**RE: SSD 7462 – Minto Recycling Pty Ltd (Bingo Industries)  
No. 13 Pembury Road, Minto**

I refer to the Department's correspondence regarding the proposal to increase the permitted tonnage of waste per annum permitted to be handled at the subject site from 30,000 tonnes to 220,000 tonnes, with some alterations/additions to existing buildings and amenities on the site.

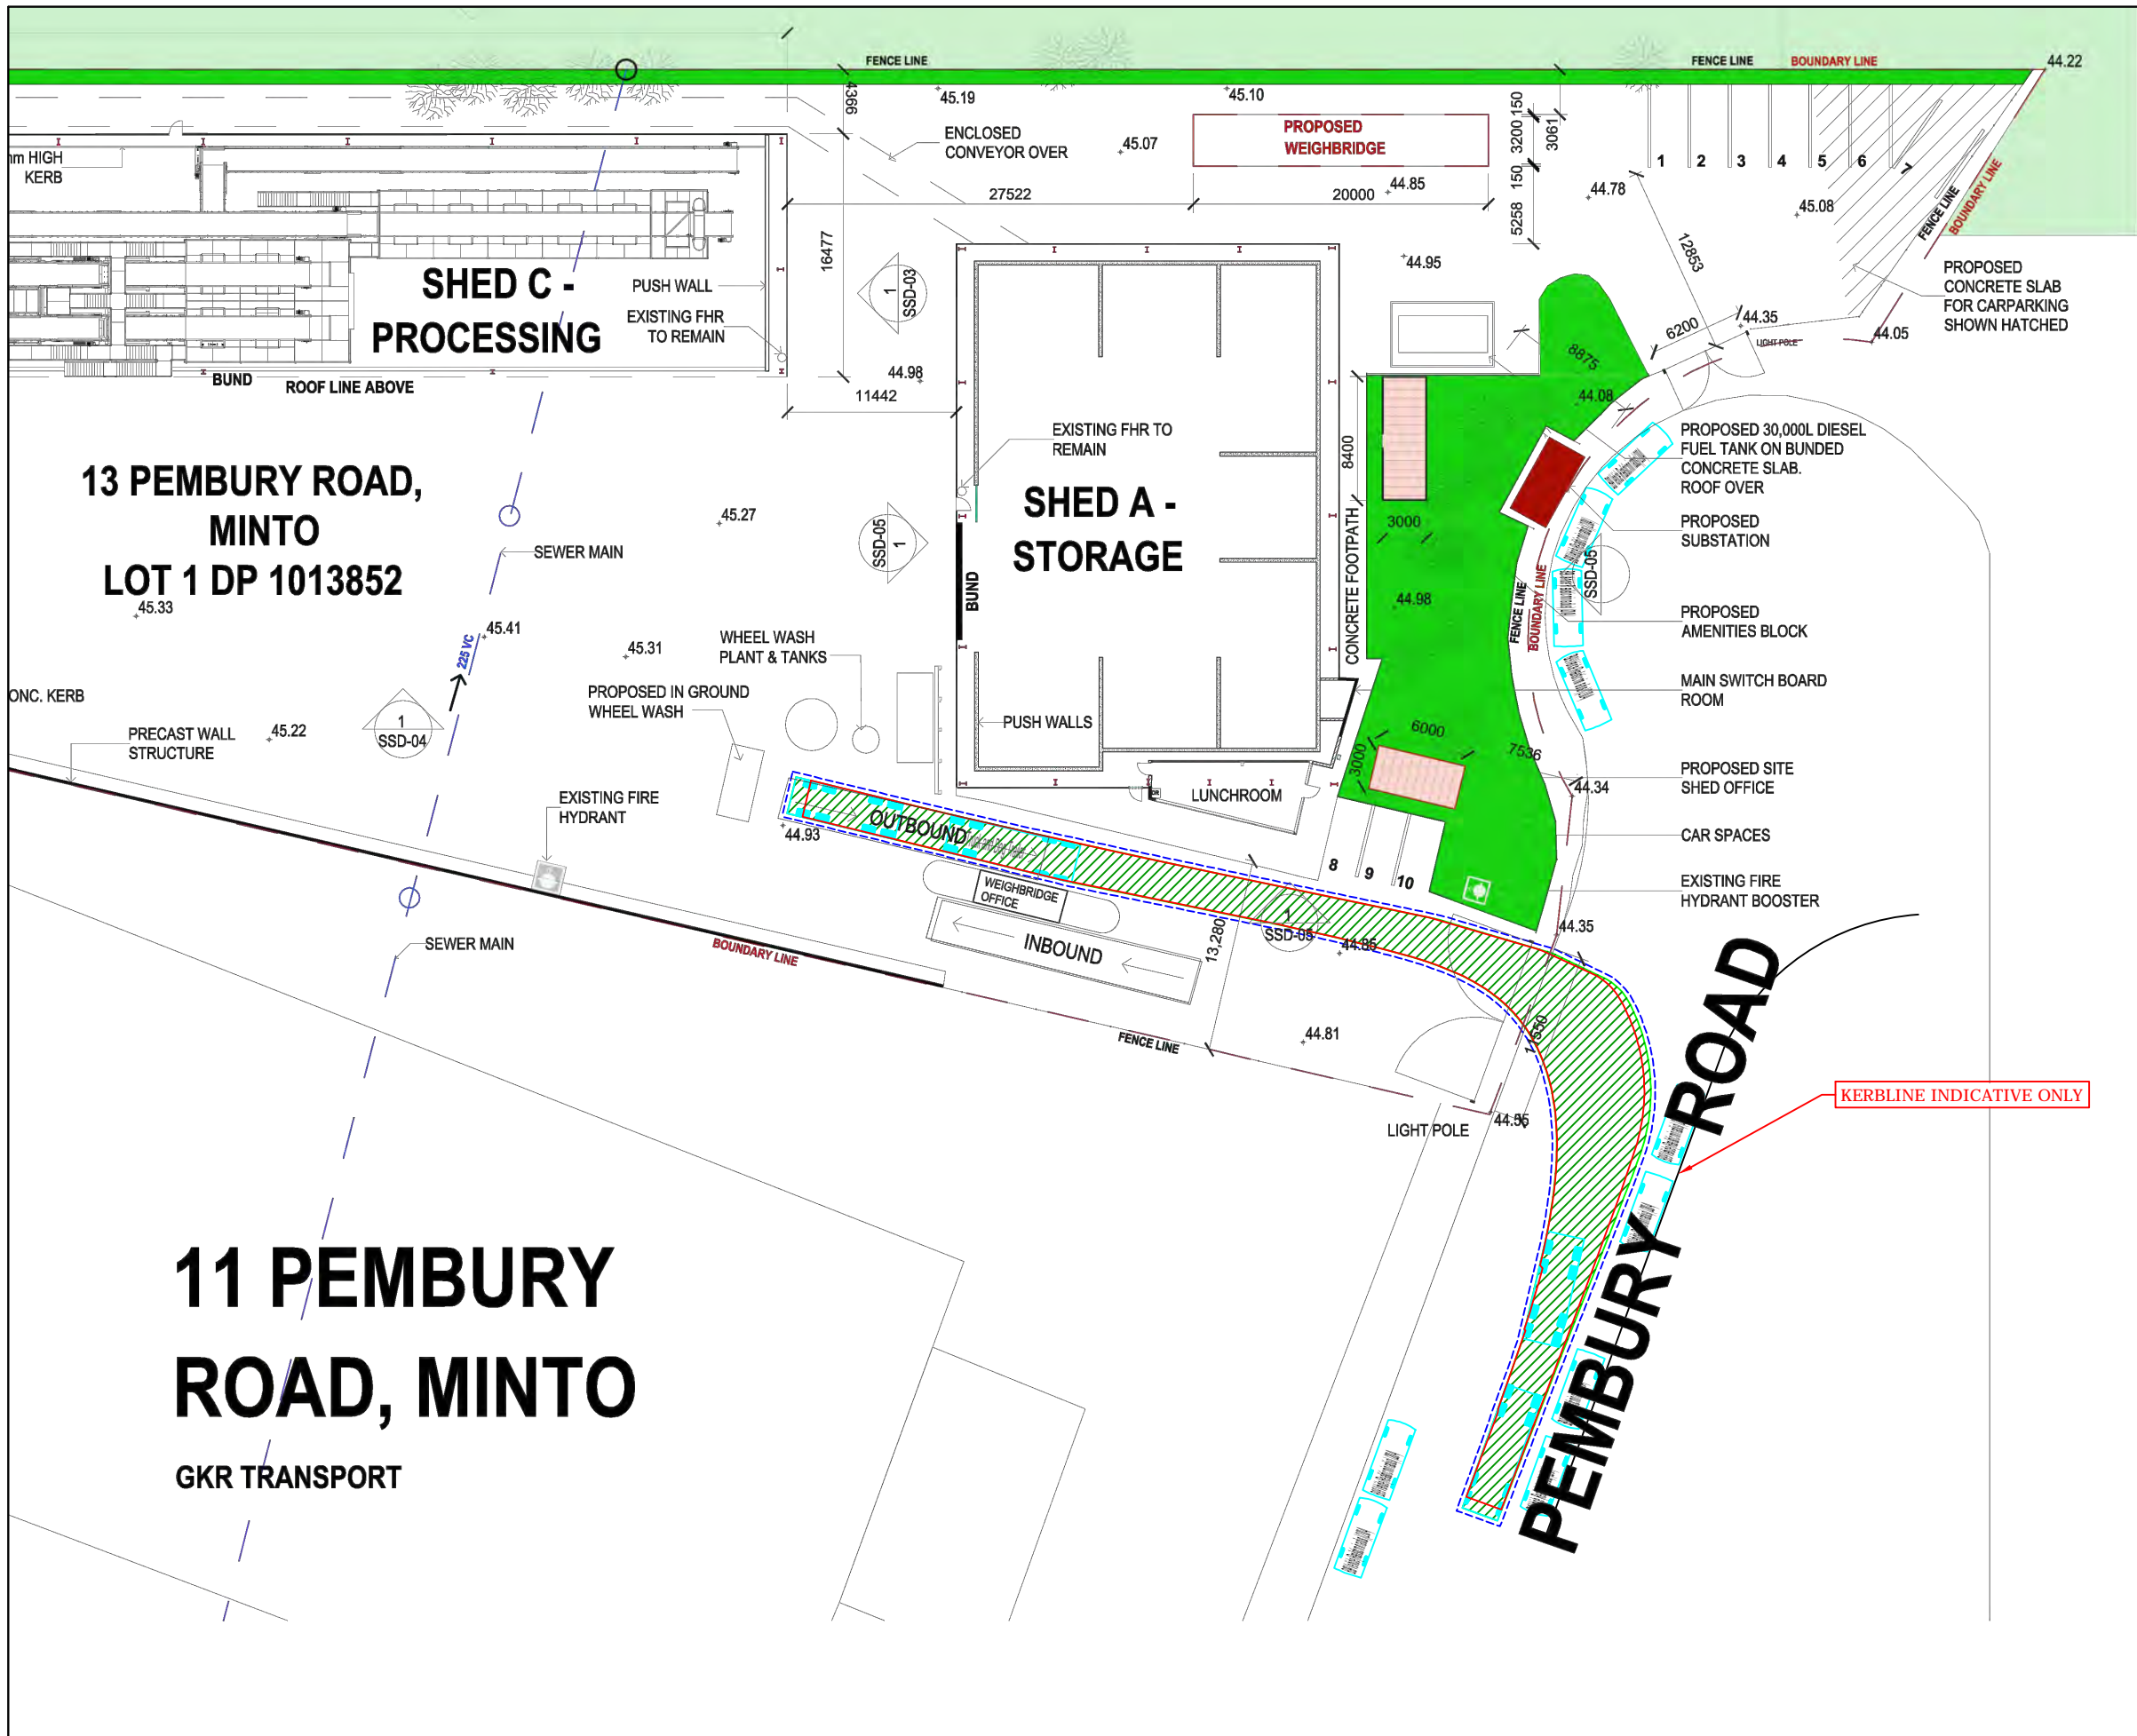
Page 112 of the EIS states that '*... there is provision to stack vehicles at the site entry prior to passing over the weighbridge, which will reduce the likelihood of queuing extending into the road reserve*'. The distance from the entry point of the weighbridge to the property boundary is approximately 20 metres. The width of the pavement between the weighbridge and the eastern boundary of the property is approximately 2.3 metres. The diagram in Figure 23 of the EIS shows two trucks stacked along the eastern boundary between the front of the property and the start of the weighbridge.

It is significantly questionable as to whether stacking of vehicles will be practical in this confined area, especially given the need for a vehicle stacked in this location to reverse a significant distance in order to manoeuvre onto the weighbridge.

TITLE
25.0m B-DOUBLE - SWEEP PATH

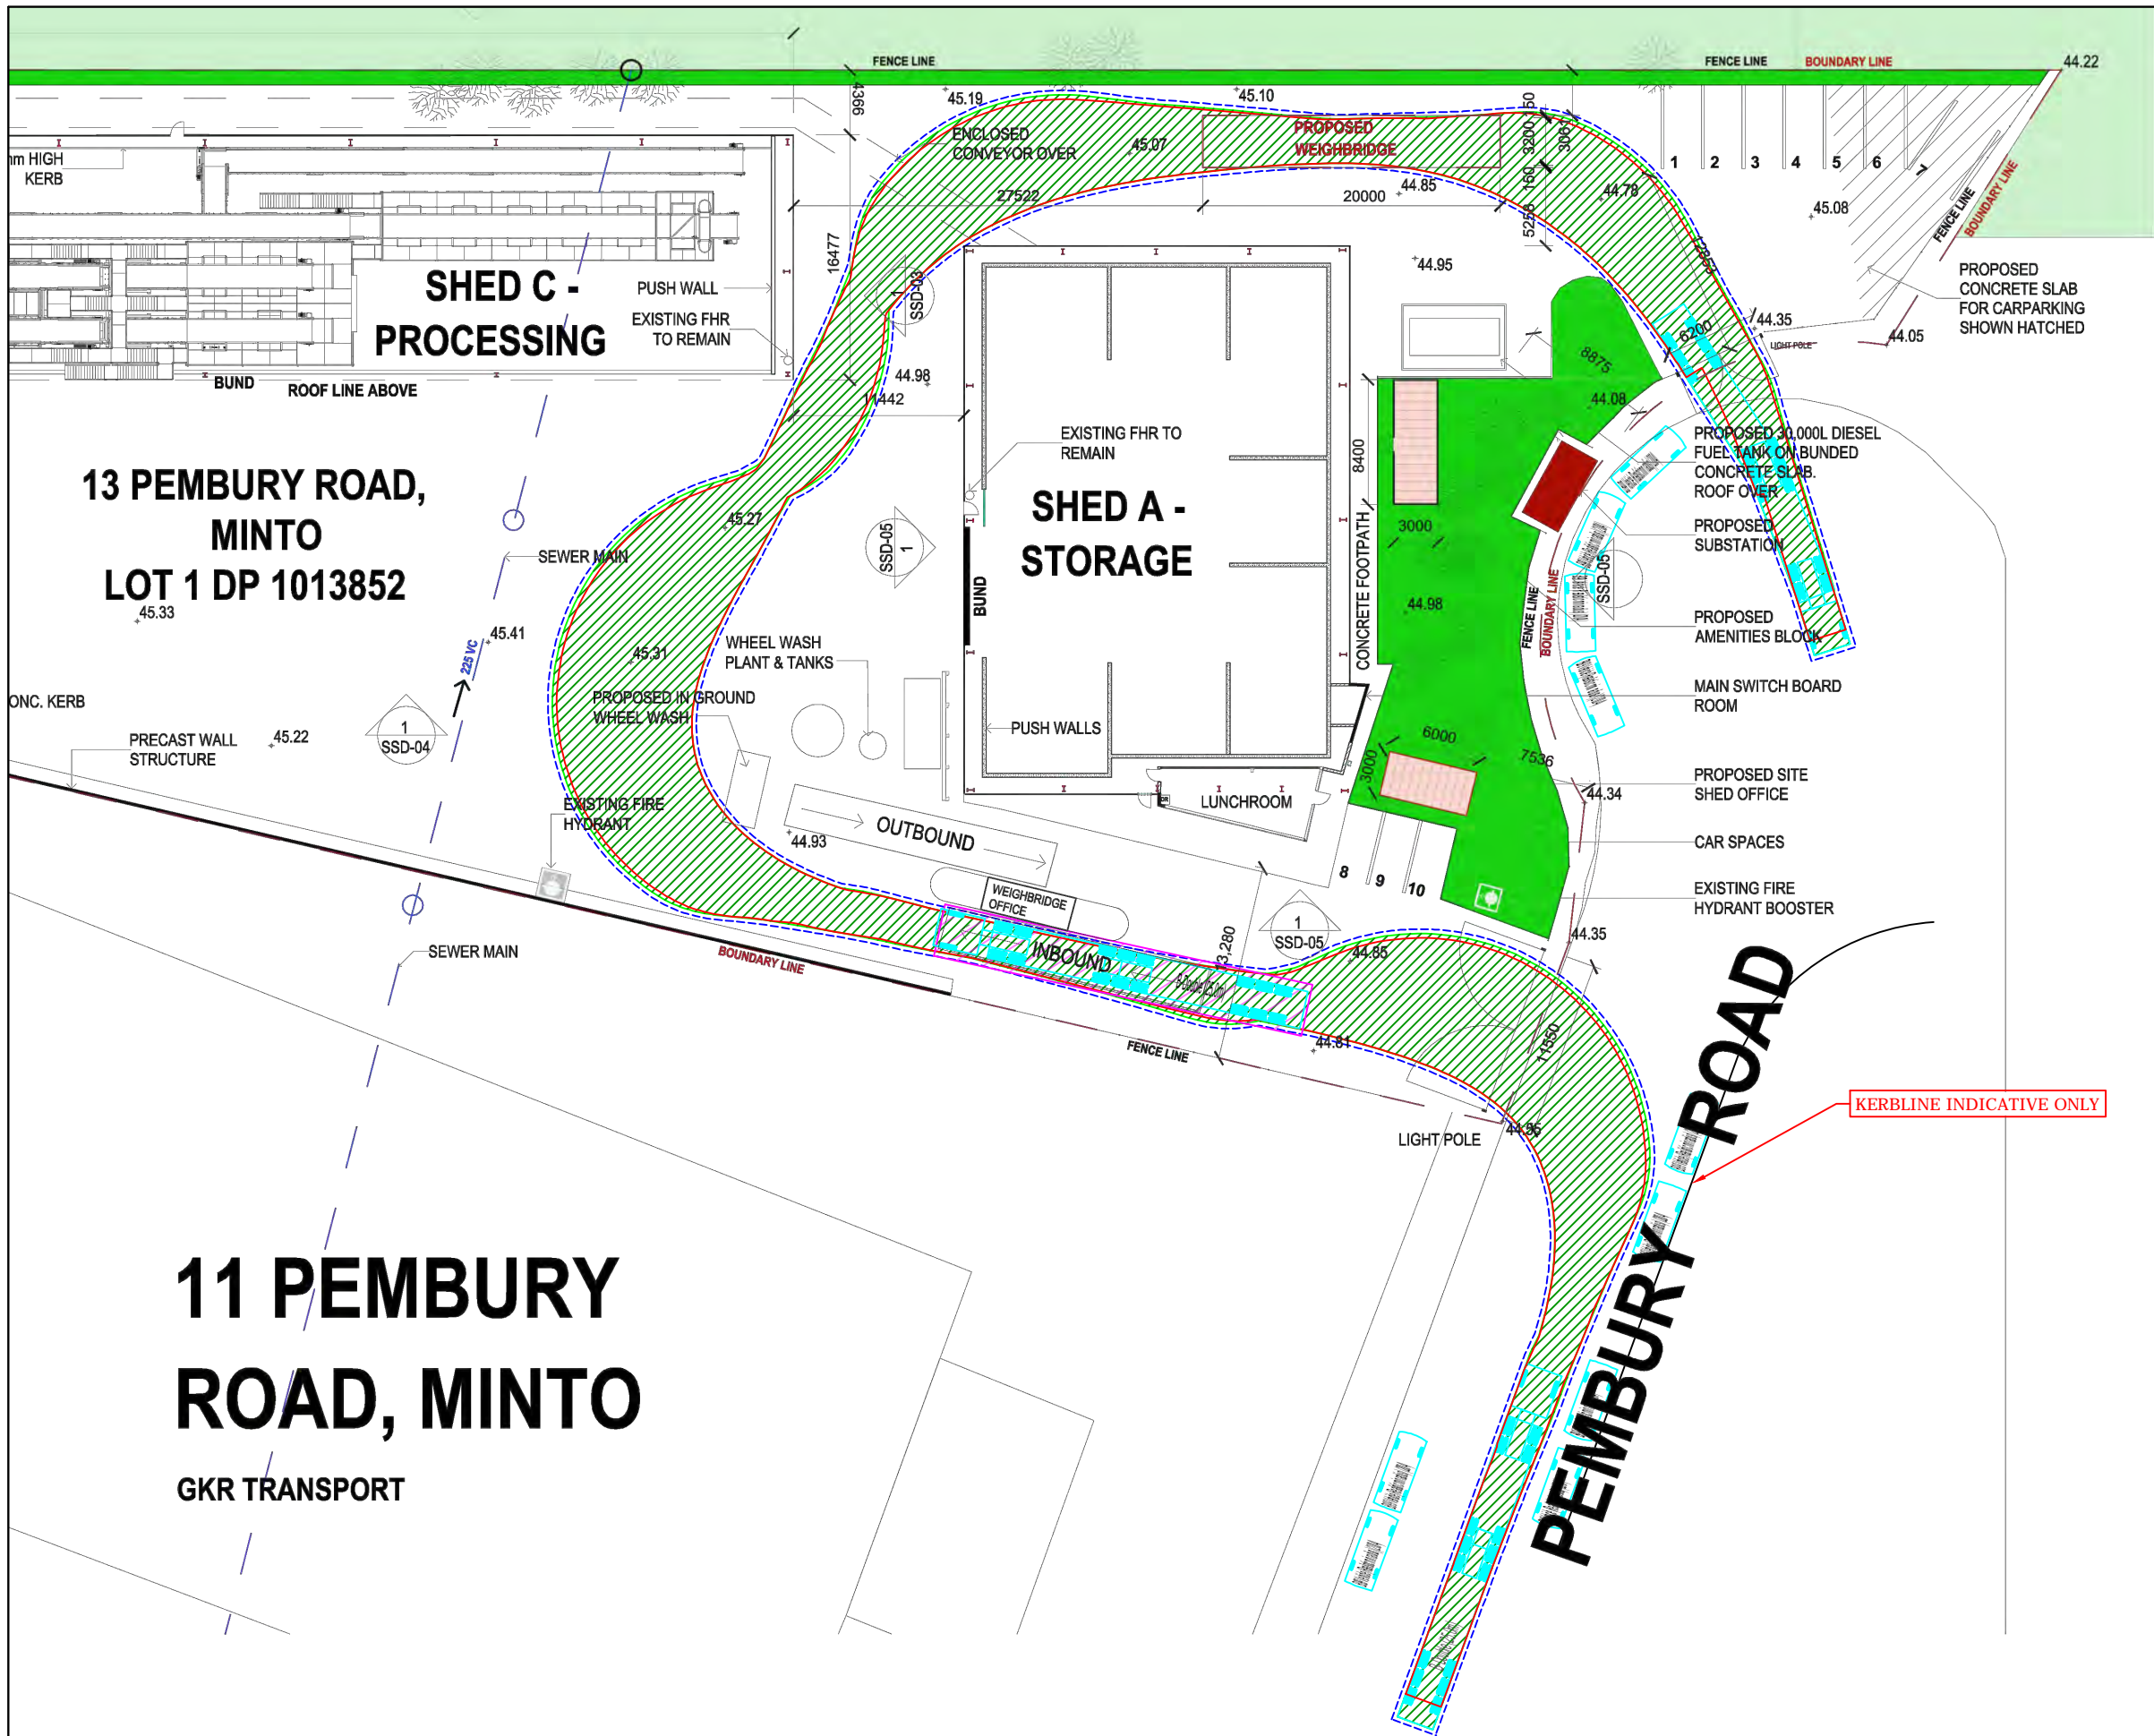
Figure 4 in the Transport Impact Statement shows that a B-double vehicle can only manoeuvre on the site if it does so from close to the eastern boundary, and provided 4-5 vehicles shown stacked in Figure 2 are removed. It should be checked that this was taken into account when on-site vehicle stacking was calculated. Given the required area to manoeuvre a B-double vehicle, it is questionable whether B-doubles entering the loading site during peak traffic flow times (eg. 7.00am to 4.00pm) is practical and desirable.

**Figure 3 Proposed flow of waste and vehicle movements**

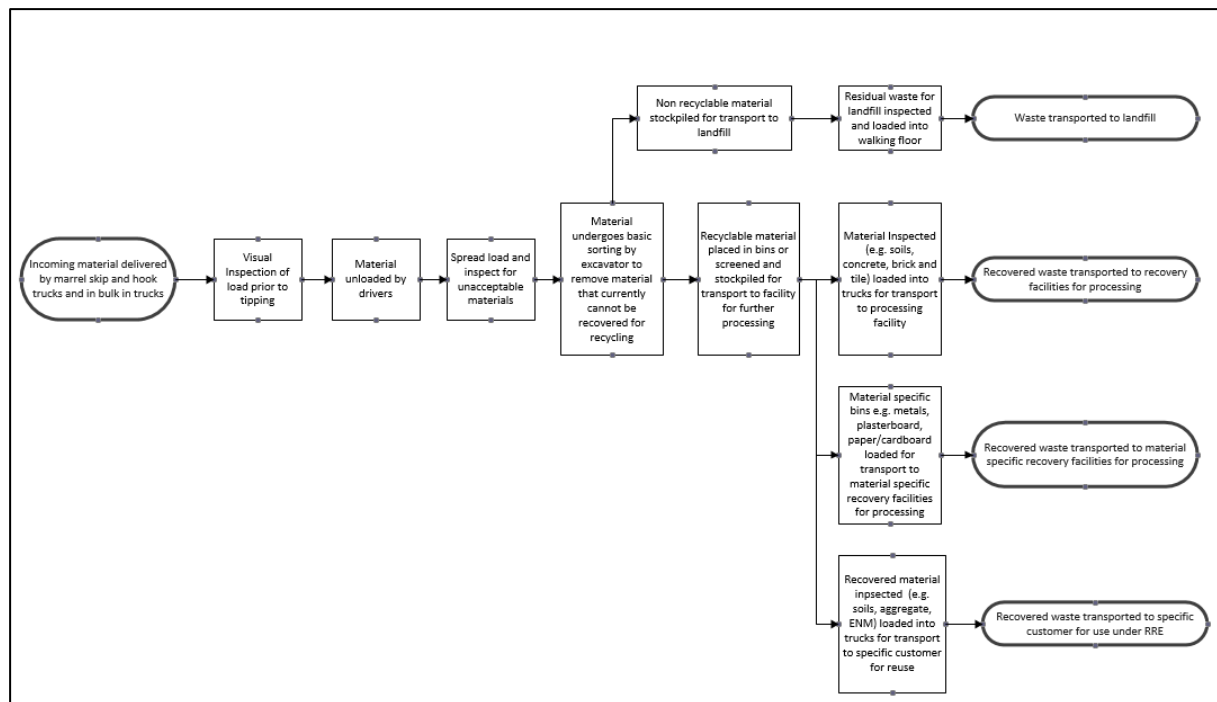
The application shows one single unloading area for all vehicles. The entrance into which the vehicle reverses to discharge the load is capable of receiving one vehicle only at a time. The Preliminary Environmental Assessment provides in Attachment B an extensive list of waste streams to be accepted, including among other items, virgin excavated natural material (VENM), building and demolition waste, soil, asphalt, garden waste, bulky goods waste, street sweepings, grits/sediments collected from stormwater management systems, office & packaging waste, vegetative waste from agriculture/horticulture, cured concrete waste from batching plants.

By the nature of some of these materials and their origins, they will be delivered as pre-sorted loads, ie. entire loads of VENM, entire loads of building and demolition waste, entire loads of vegetation material, etc. Given the single unloading area proposed, for many loads the discharged waste will need to be cleared from the discharge area prior to the next vehicle's discharge, to prevent cross-contamination of waste streams. This may delay unloading, resulting in reduced vehicle movements per hour. More information is needed as to how the proponent proposes to maintain the integrity of each pre-separated waste stream.
